**Re: Objection to the Proposed Tirawley Wind Farm Strategic Infrastructure
Development Objection Submission to An Coimisiún Pleanála**

Re: Planning permission for the construction of Tirawley Windfarm consisting of 16 no. wind turbines, a permanent 110kV substation, 110kV underground cable and grid connection, and ancillary development in the townlands of Ballymurphy, Ballynaleck, Barnhill Lower & Upper, Barroe, Billoos, Carn, Carrickanass, Carrowmore, Castlелacken Demesne, and other townlands in County Mayo.

| 6289 | PL-2001 | 0 |

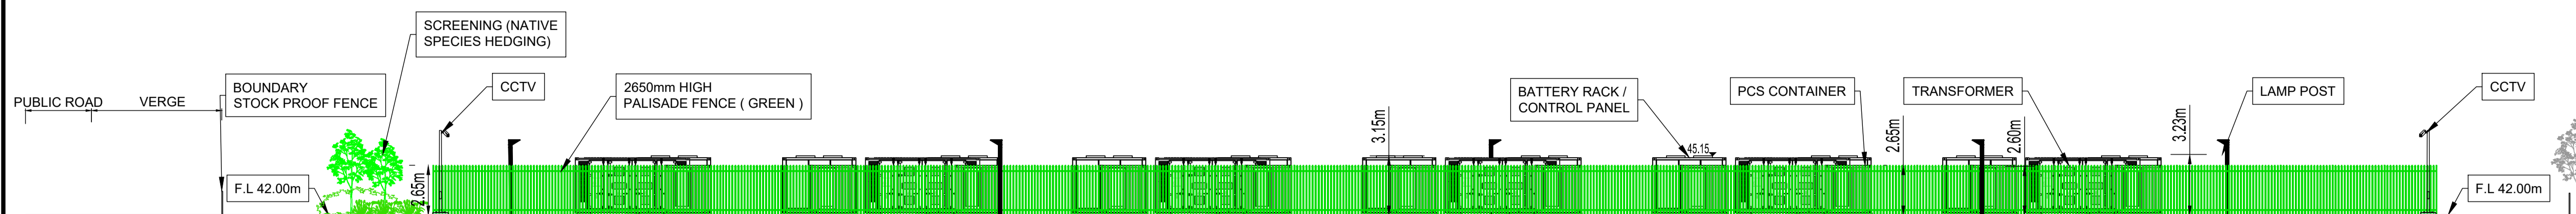
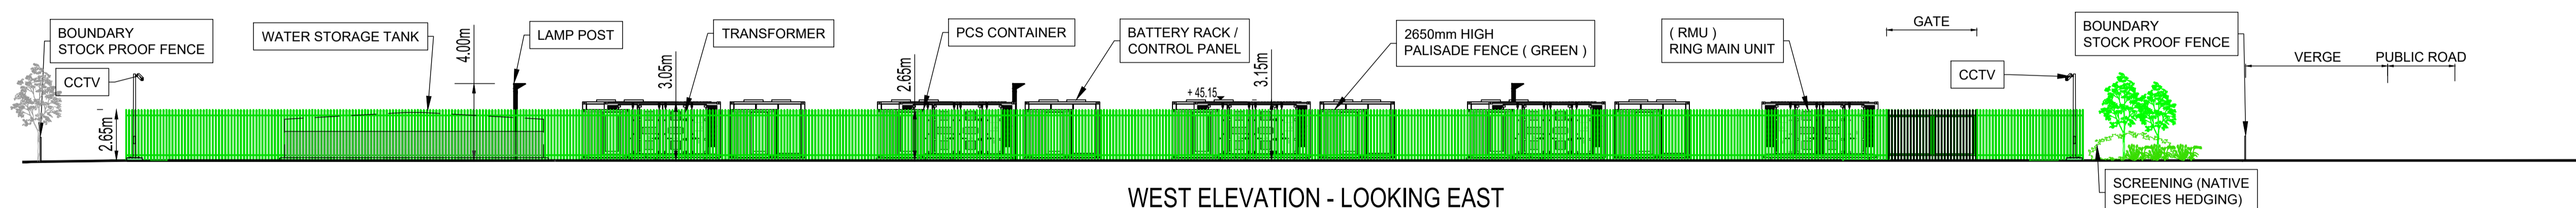
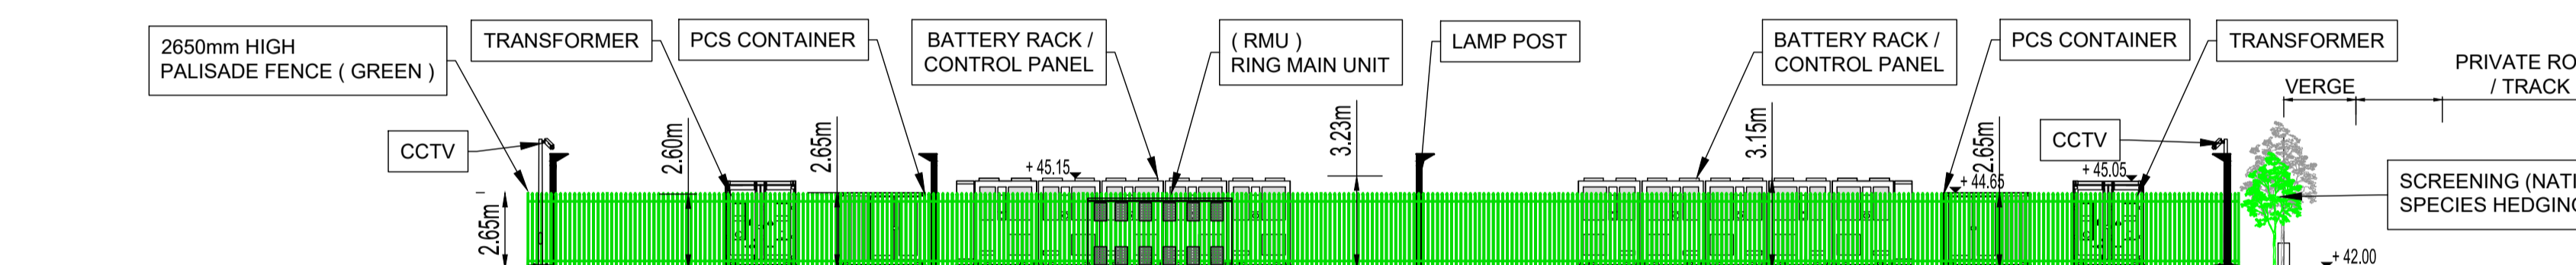
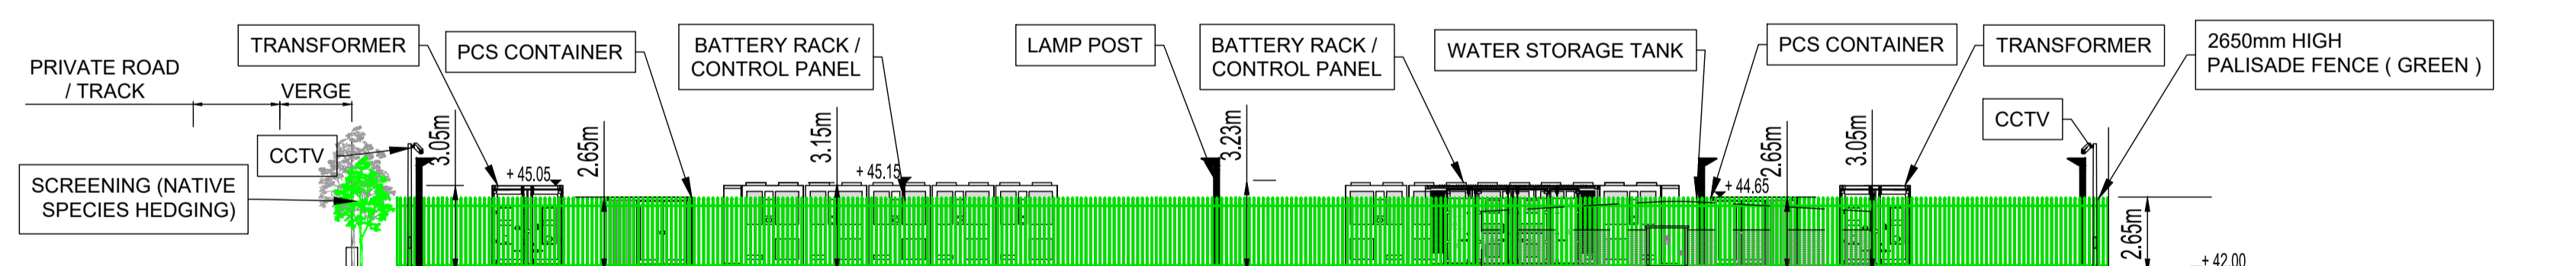
The BESS layout drawing reveals a substantial industrial compound comprising:

- Multiple rows of lithium-ion battery storage containers
- A large fire water storage tank
- Transformer units
- Electrical control panels
- Perimeter security fencing (shown on all four elevation drawings)
- Internal access roads
- Lamp posts / security lighting
- Landscaping screening bunds on all four sides

...require that the public be given adequate, specific, and meaningful notice of the actual development being proposed. A BESS compound visible across four elevation drawings — with battery containers, transformers, fencing, a fire water tank, and security lighting —

The BESS layout drawing shows a fire water tank but:

1. The capacity of the fire water tank has not been specified or assessed as adequate for a multi-day lithium-ion fire.
2. The fire suppression strategy for the battery containers has not been submitted (lithium-ion fires require specialist suppression — standard water application can be counterproductive).
3. The fire safety assessment submitted (Appendix 16.1) relates to the wind farm generally and does not constitute a BESS-specific fire risk assessment.
4. The separation distances between individual BESS container units visible in the layout drawing have not been assessed against any Irish, UK, or international standard (e.g., NFPA 855, IEC 62933).

The BESS layout drawing and elevation drawings clearly show a substantial fenced industrial compound comprising:

- Multiple rows of battery containers (visible at height above perimeter bunding)
- A large circular fire water storage tank
- Transformer units at multiple locations around the compound perimeter
- Security fencing and lamp posts on all four sides
- Internal access roads

The compound is described in the title block as drawn at 1:290 scale — indicating a facility of considerable physical extent. Yet:

- A standalone BESS Fire Risk Assessment prepared by a chartered fire safety engineer must be submitted.
- Fire suppression strategy, container separation distances, and water supply adequacy for a multi-day fire must all be assessed and documented.
- The assessment must be reviewed by Mayo County Council Fire Authority and the Health and Safety Authority (HSA) before any planning determination is made.
- Minimum separation distances between BESS container units must comply with NFPA 855 (2023) or equivalent standard, and compliance must be demonstrated in the submitted drawings.
